**RFI**

**RFI #:** 64  
**Date:** 2/22/2012  
**Job:** EB-02 Keller Springs Lofts  
**Phone:** 877-777-5115

**Subject:** Exterior Door Frame Clarification

**Subject:** Substitute PT for Woodtone Real Trim

2.0A

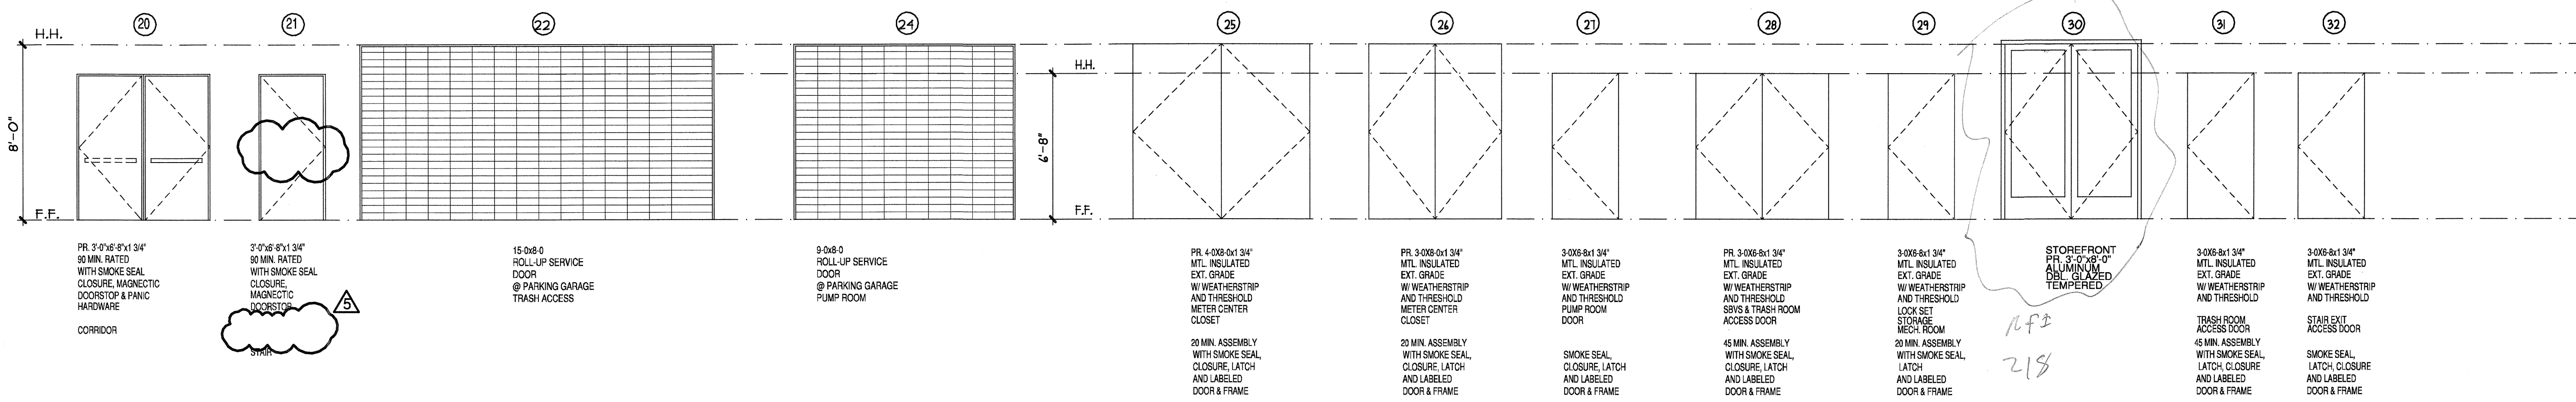
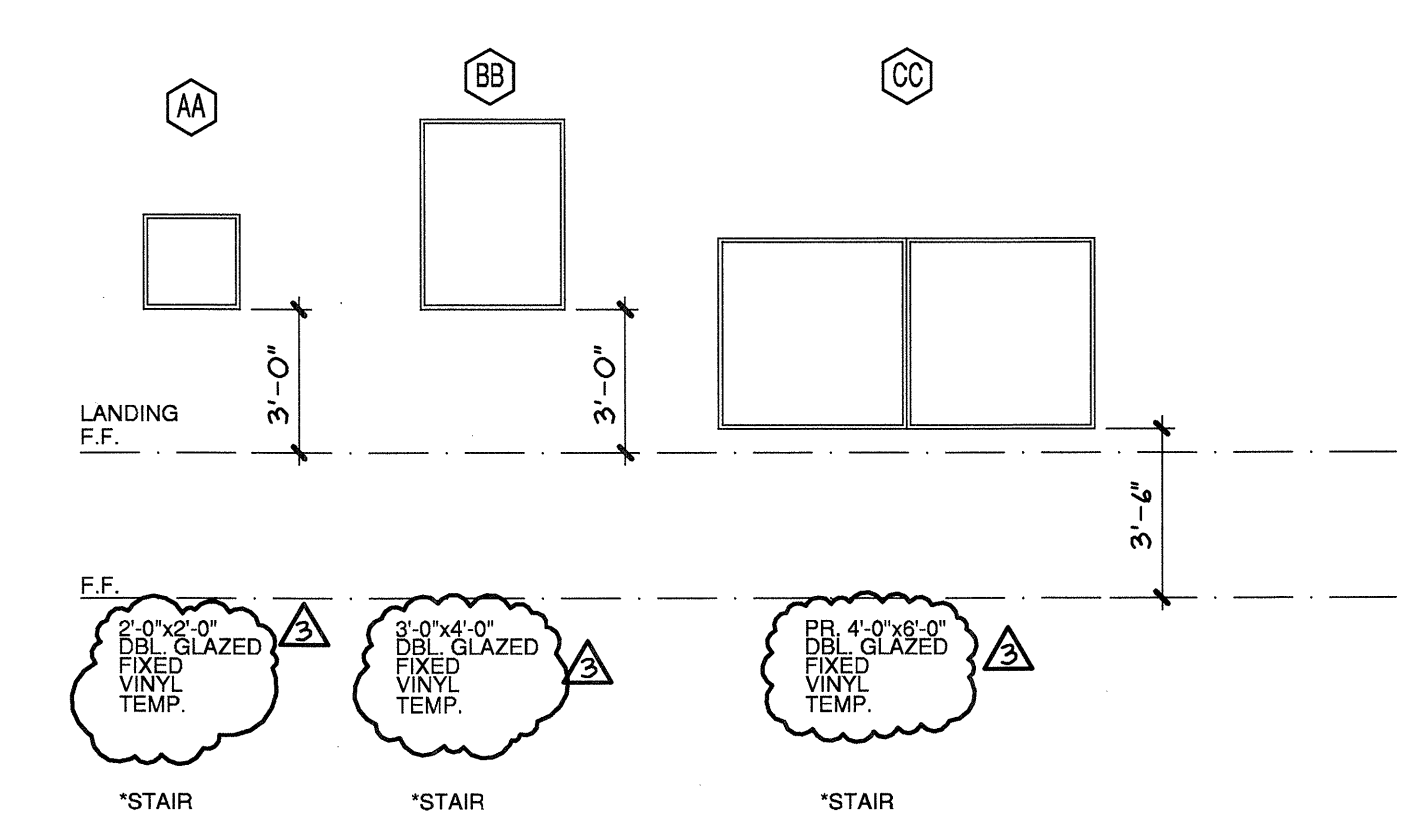
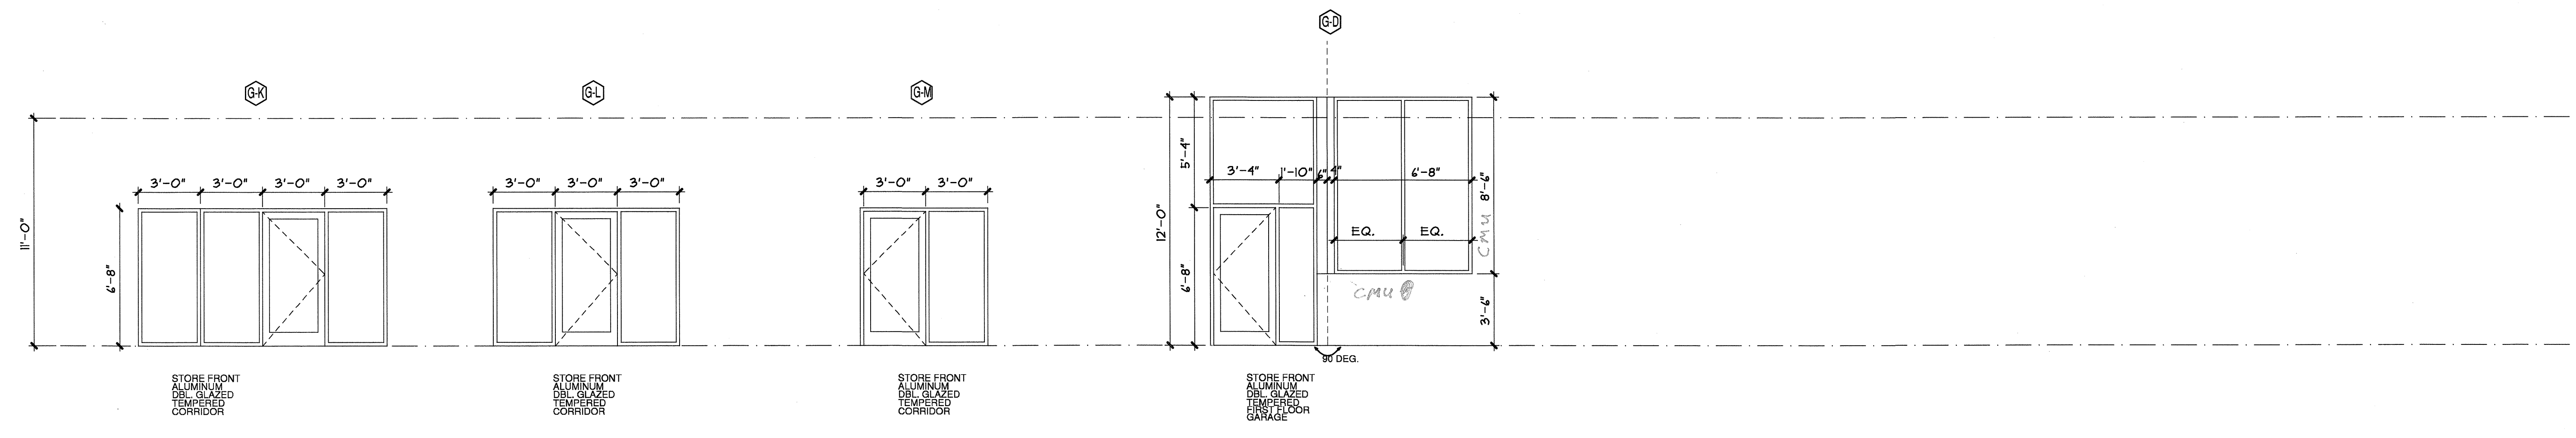
**Request:** Arch sheet 2.0 does not specifically describe all door frame material applications. When referenced in the plans to detail sheet 8.4-5/6, the jambs are indicated as aluminum door frames at stucco. Plans also indicate on sheet 8.3-13/14, that the door frames are to be wood. Please coordinate and confirm acceptance of wood door frames with brick molding at all exterior door applications.  
**Date Required:** 2/29/2012

**Response:** Yes, it is acceptable to use wood frames.
